15 November 2019

File No: 2019/572869
Our Ref: R/2014/33/I & R/2018/13/A
Your Ref: MP 06_0171 MOD 16 & SSD-9374

Request for advice – Modification of Central Park Concept Plan (MP 06_0171 MOD 16) and Block 4B Central Park Adaptive Reuse (SSD-9374)

Ground Floor Plan

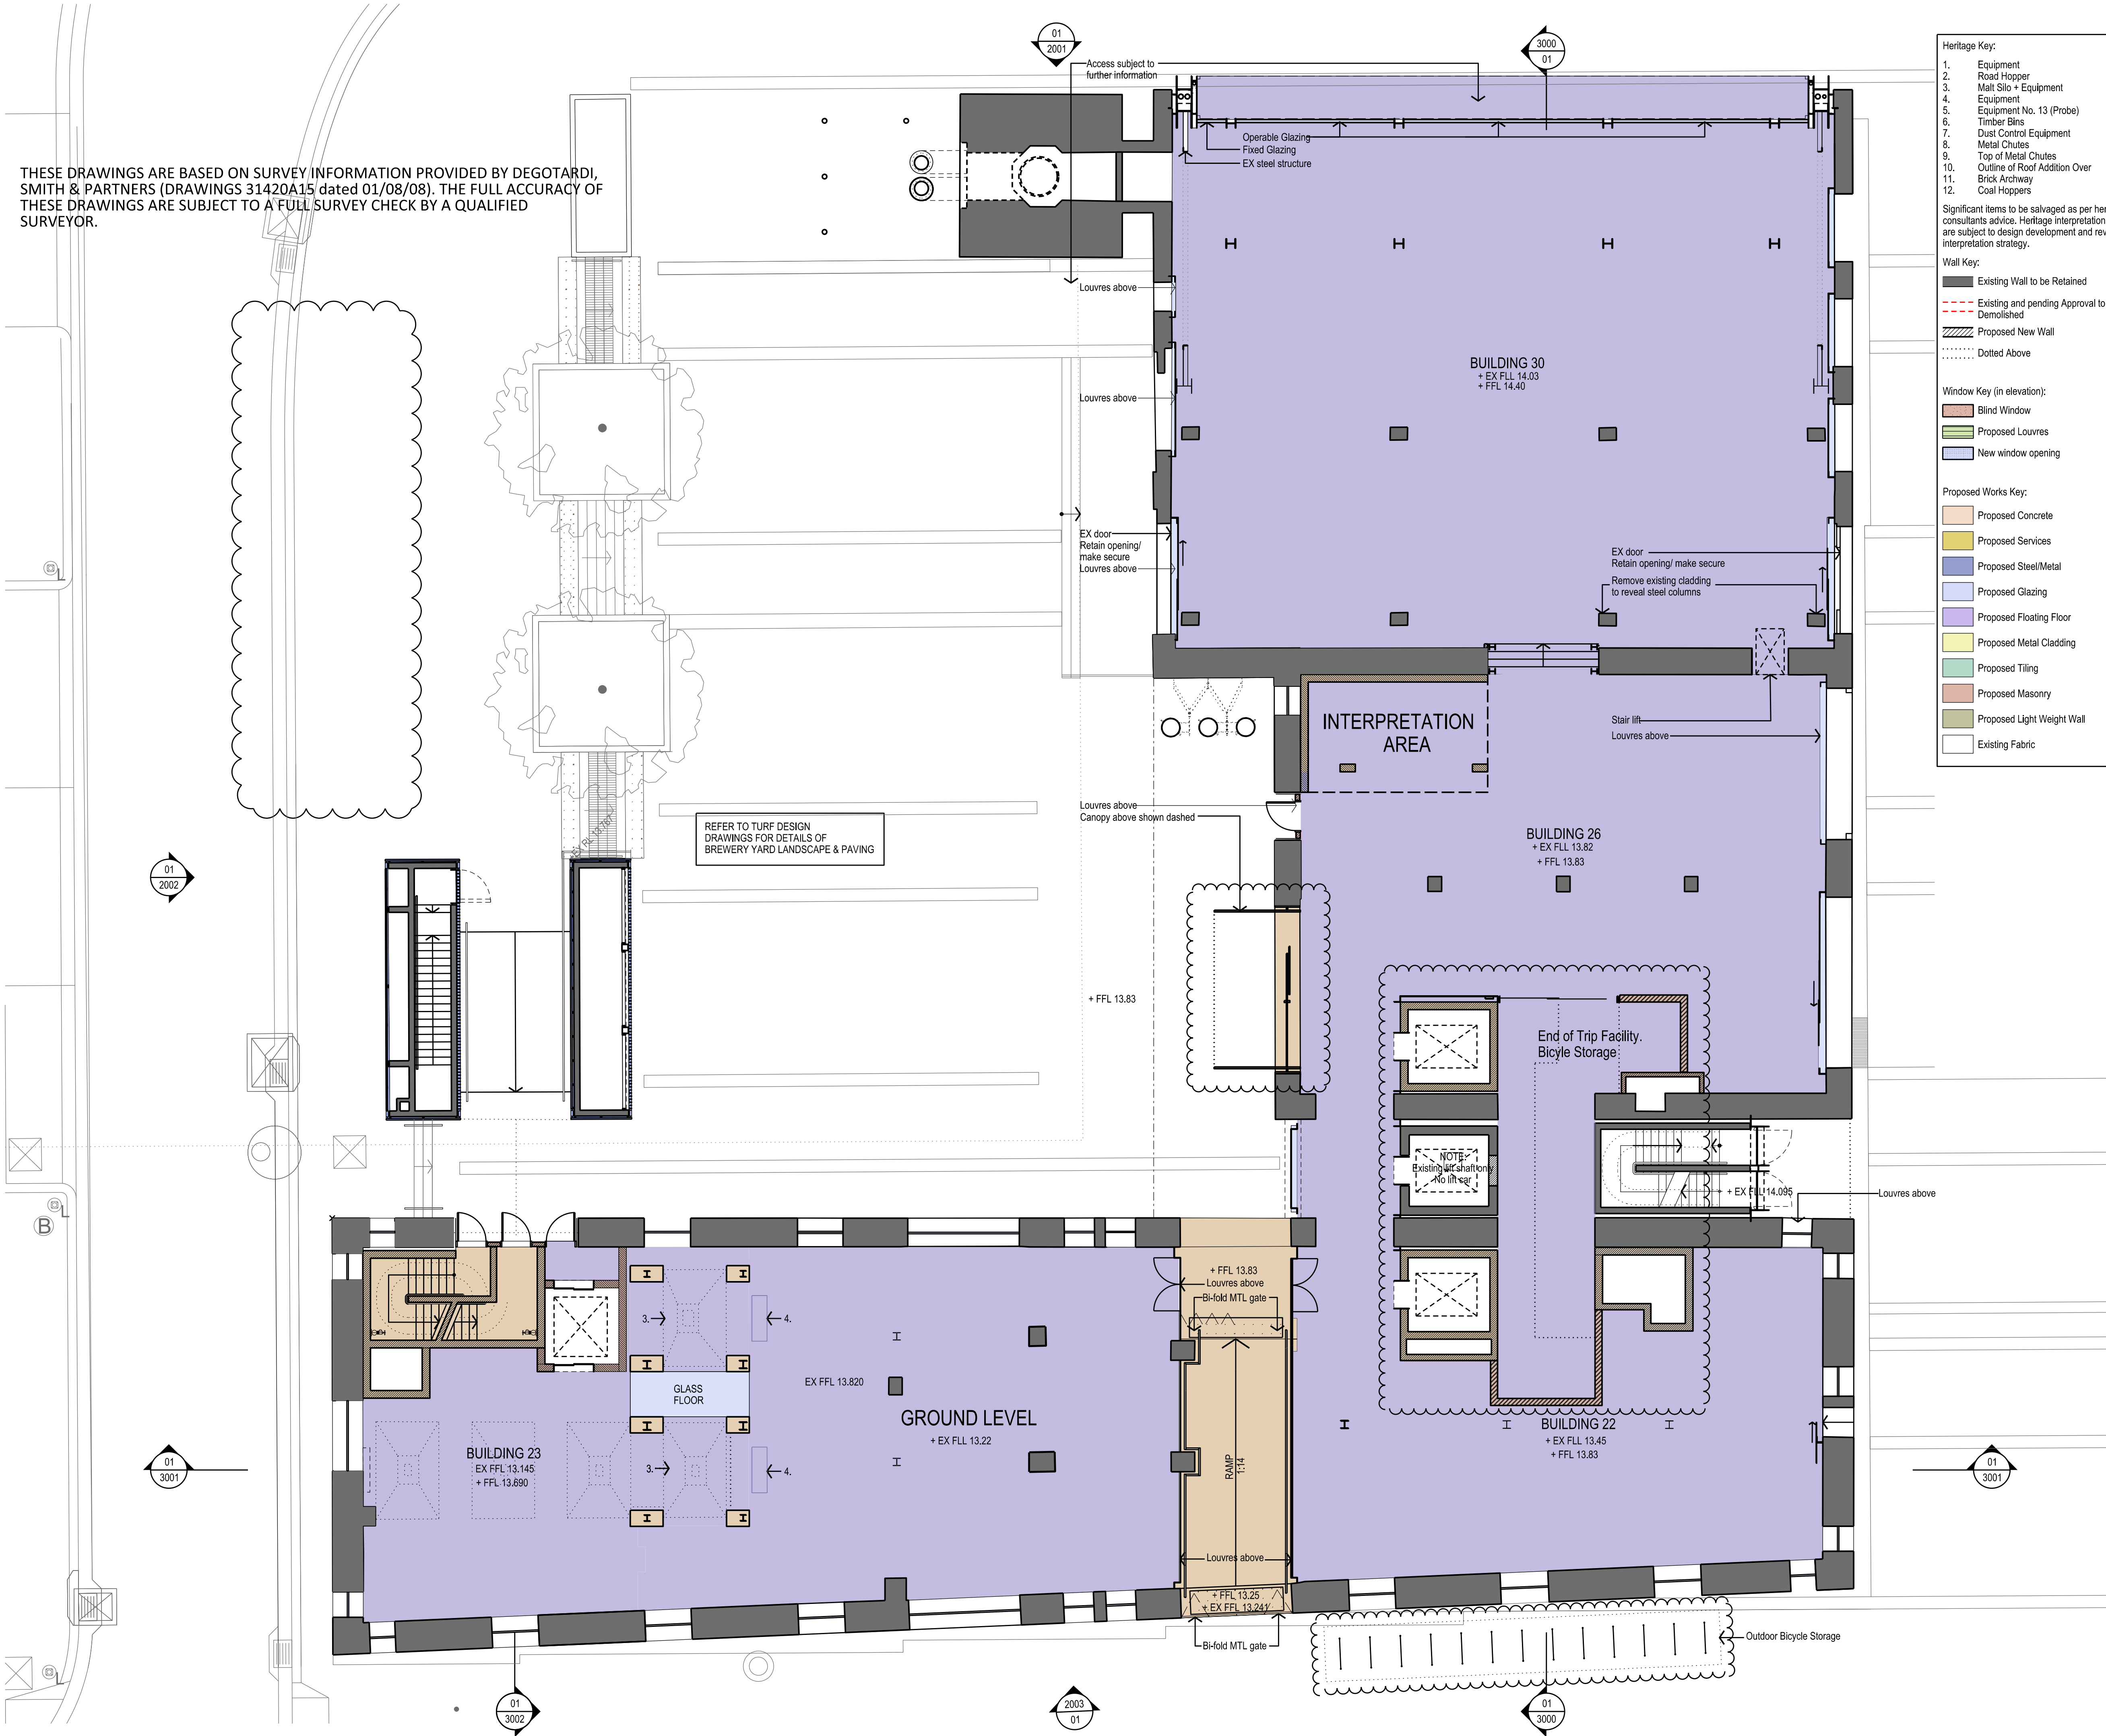
The combination of the new foyer and the location of the through site link results in a pedestrian connection that lacks a clear view into or from the central square. A direct visual connection from one space to another is critical in the success and safety of this pedestrian route. It is recommended one of the following amendments be made to the layout to resolve this issue:

- Remove the new foyer addition to 'un-block' the view.
- Reconfigure the foyer to remove the southern protrusion, and enable a direct but oblique view of the through site link from the square.
- Reposition the through site link to the adjacent carriageway bay (to the west), enabling both the retention of the foyer and a clear view through the pedestrian connection.

In addition, it is recommended that a detailed plan be submitted showing how an AS 1428.1 compliant landing will marry with existing footpath levels to the southern end of the through site link where the landing will protrude beyond the building line.

Level 6 Floor Plan

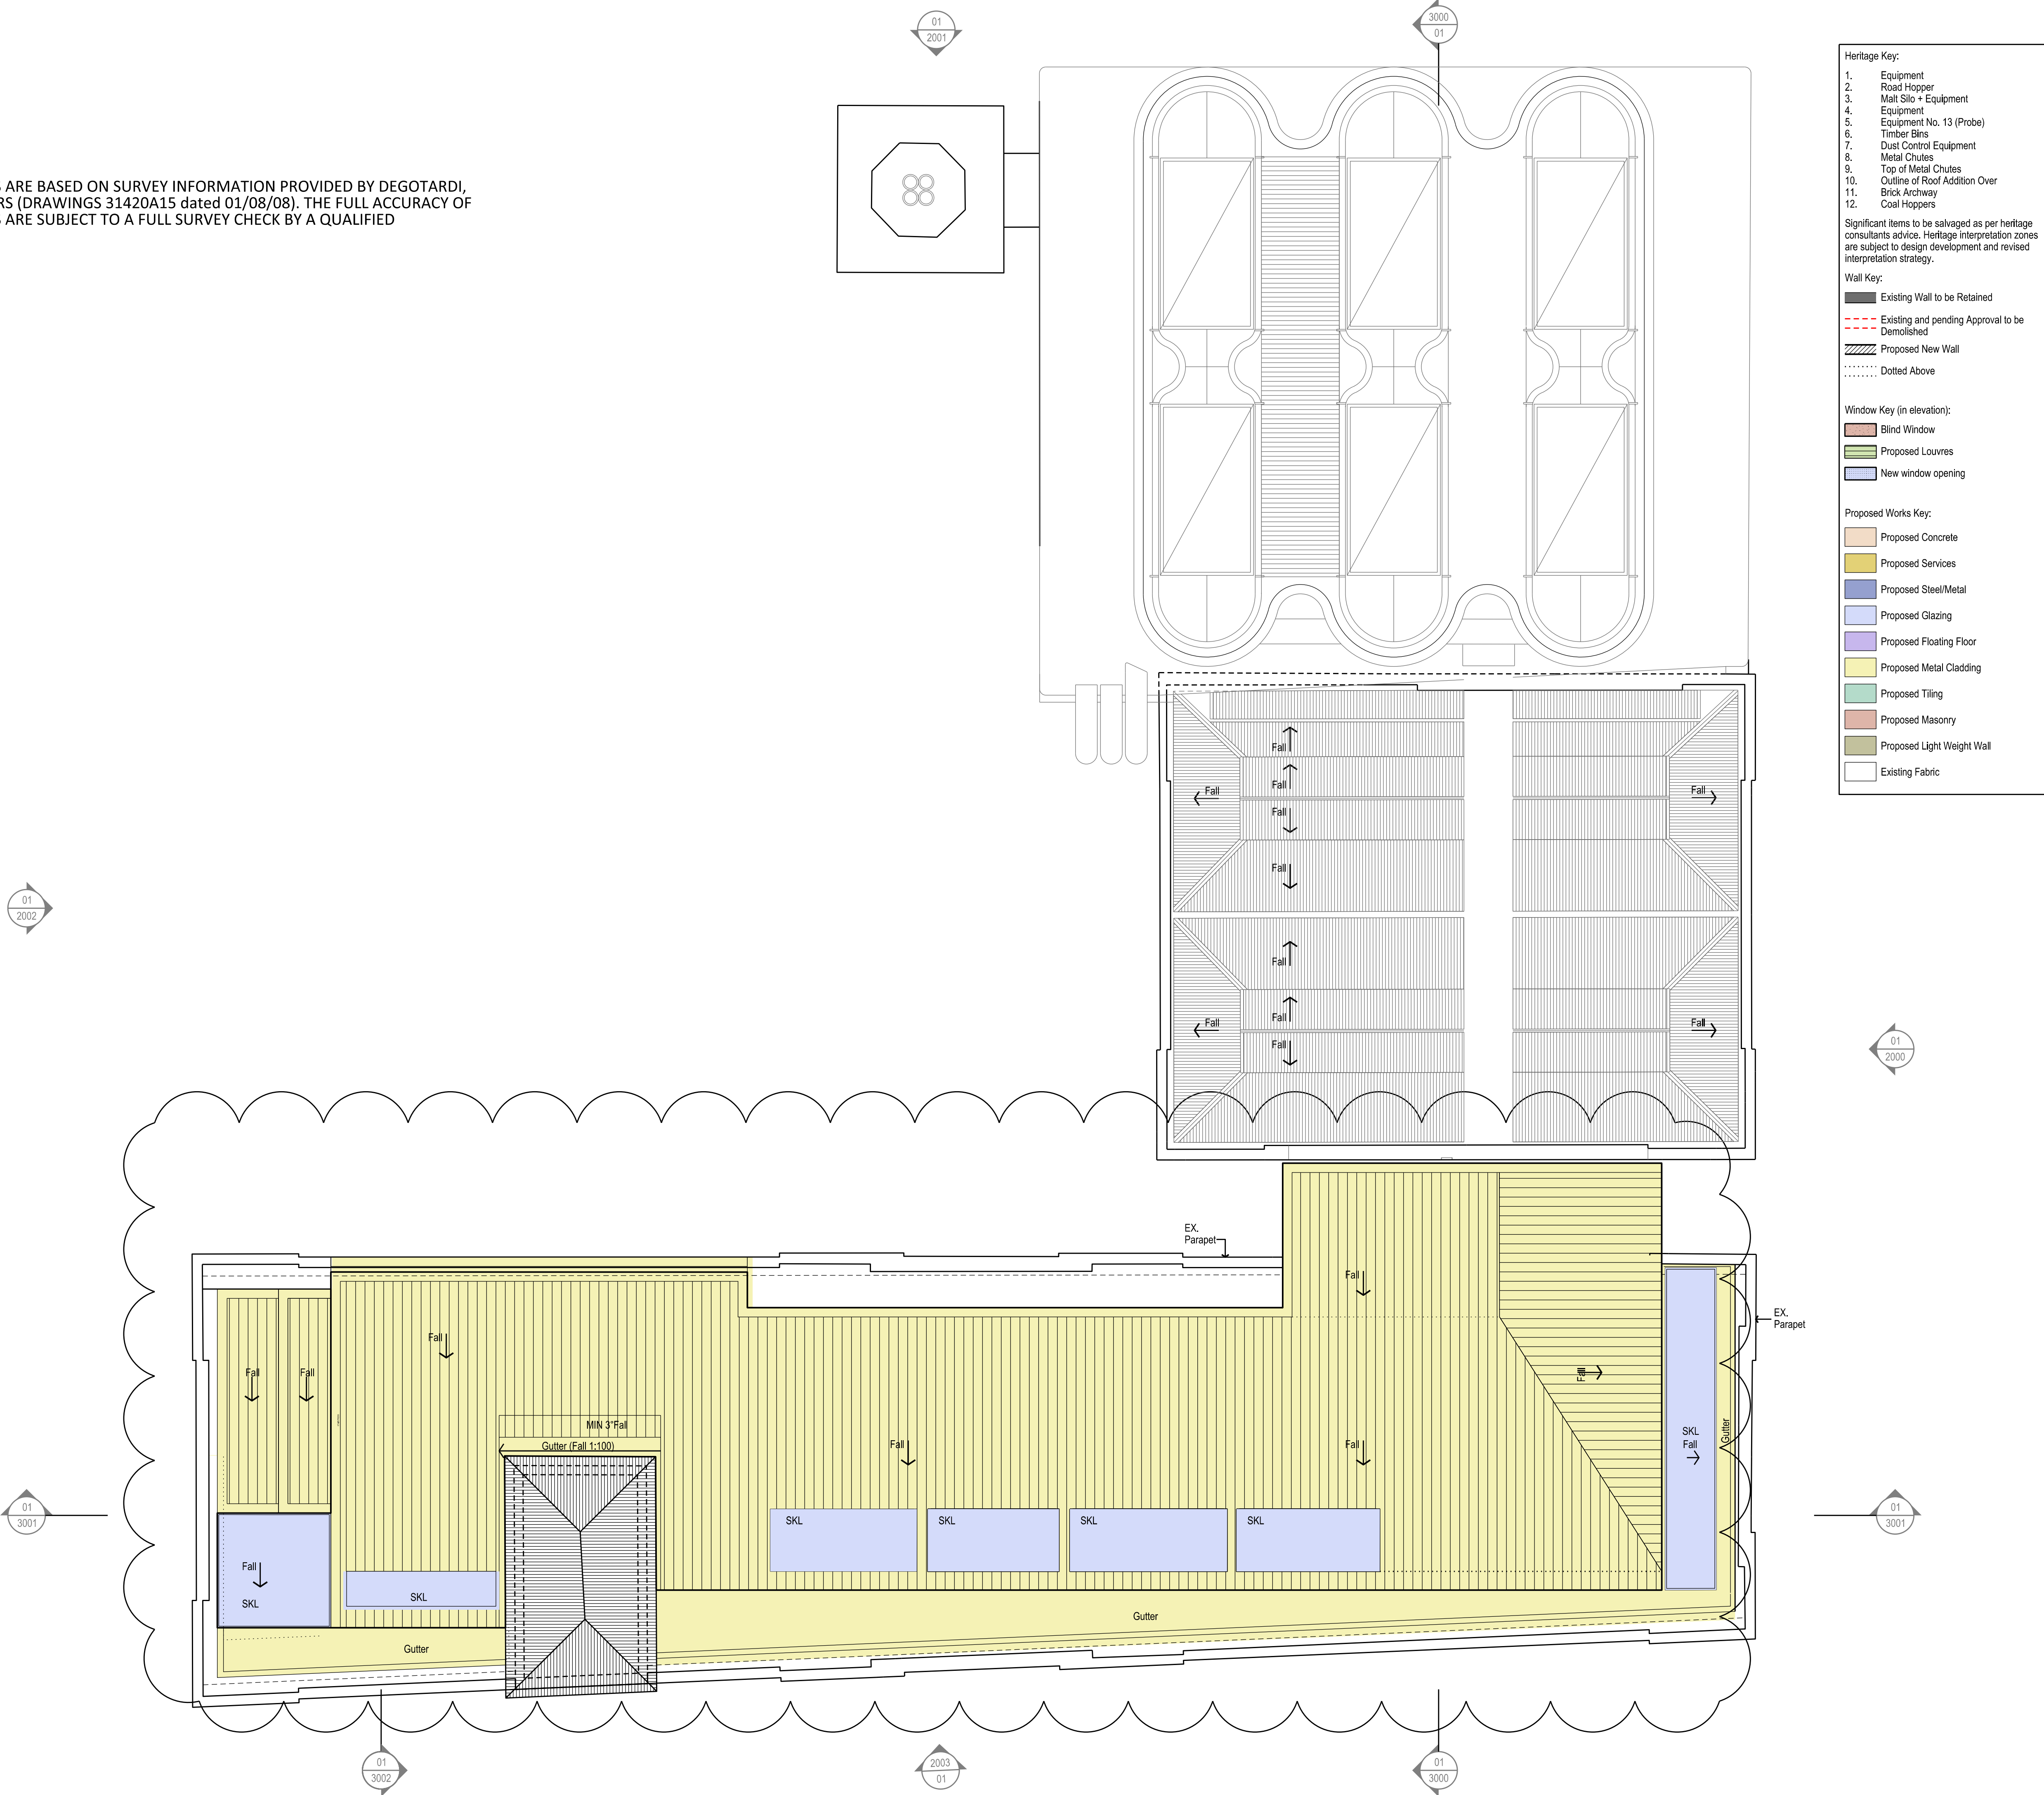
1.1 Rooftop Addition

The proposed roof addition provides for an additional 2 floors. The addition is distinct from the original masonry form of the building, it comprises glazing and metal materiality to distinguish. Its construction requires the removal of the existing gabled truss roof and one of the two towers. The additional floors will be apparent in views from the north towards the northern elevation of Building 22/23. Its form is supported but the impact on heritage fabric is high. The form does not draw an objection from the City but notes the impact on the heritage significance of the site is high.
